## **Central Bedfordshire Council**

**An application for Development Consent Order for an up to 299 megawatts (MW) gas fired peaking power generation plant designed to produce electricity, along with associated development, such as a gas connection and electrical connection at Rookery South Pit, near Stewartby, Bedfordshire**

## **PROPOSED WRITTEN RESPONSE TO EXAMINATING AUTHORITY'S WRITTEN QUESTIONS**

TYPICAL SECTION DETAIL OF THE INTERCEPTOR CHANNEL SCALE = 1:50
DEPTH AND FOOTPRINT MAY VARY LOCALLY TO RESPOND TO CONVEYANCE REQUIREMENTS

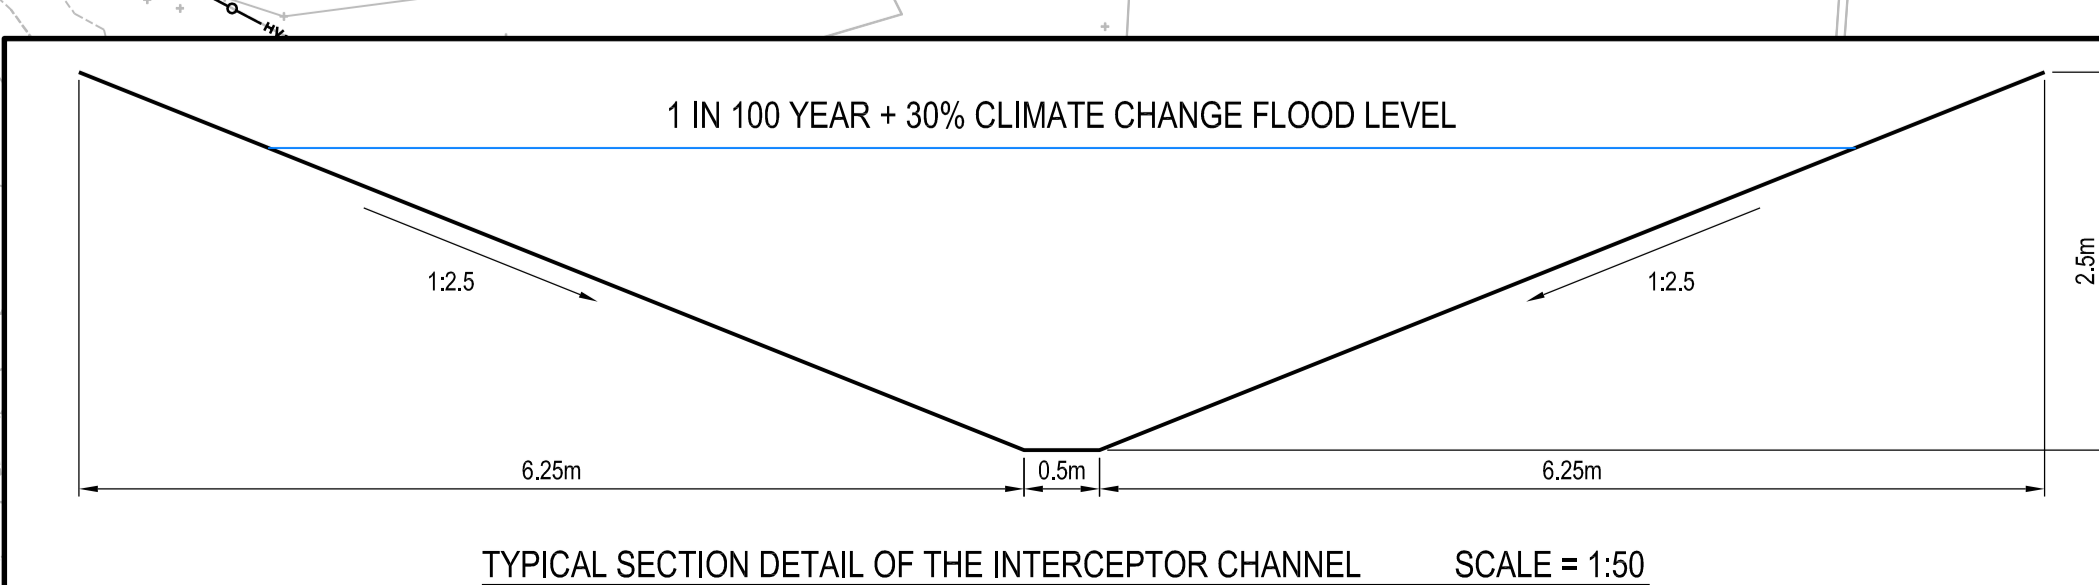
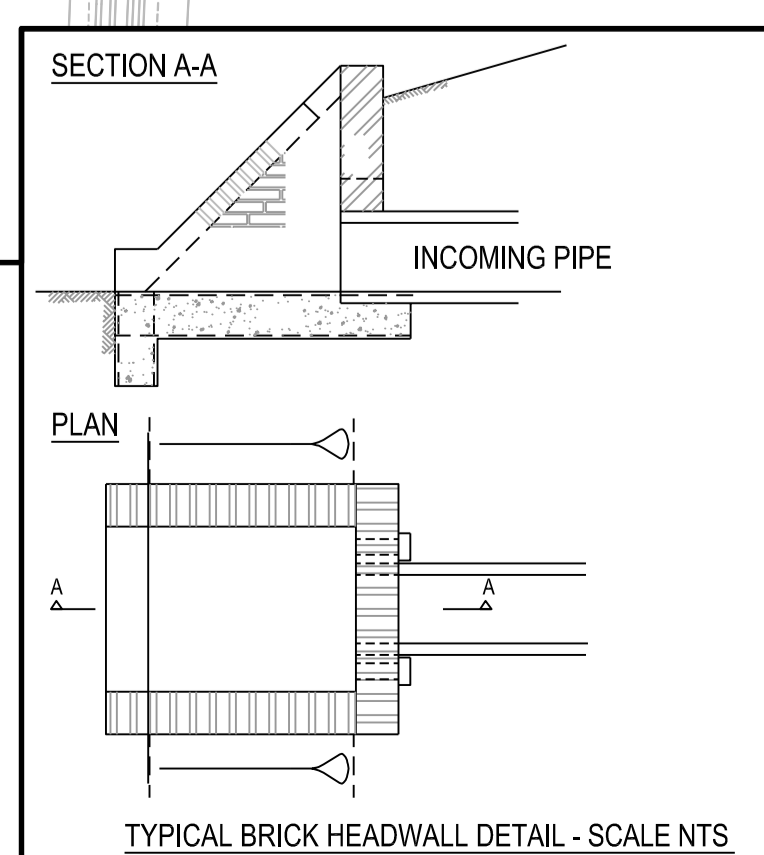
**1.11.3. The LLRS drainage works defined in the DCO provides for the construction of a drainage channel which is different from the one provided for in BC/CM/2000/8. In the EM it is argued that the revised location is not materially different to that proposed under the planning permission. Have the party responsible for implementing the LLRS and CBC expressed any view about whether there would be any conflict with the planning permission and whether any variation of the planning permission would be required?**

The Council consider that the proposed drainage channel is sufficiently different from the approved scheme that an application for a formal amendment should be submitted. This could be in the form of an ‘either/or’ proposal to amend an approved scheme as opposed to a S73 variation to a planning condition. It is not anticipated that there would be any fundamental objection to this.
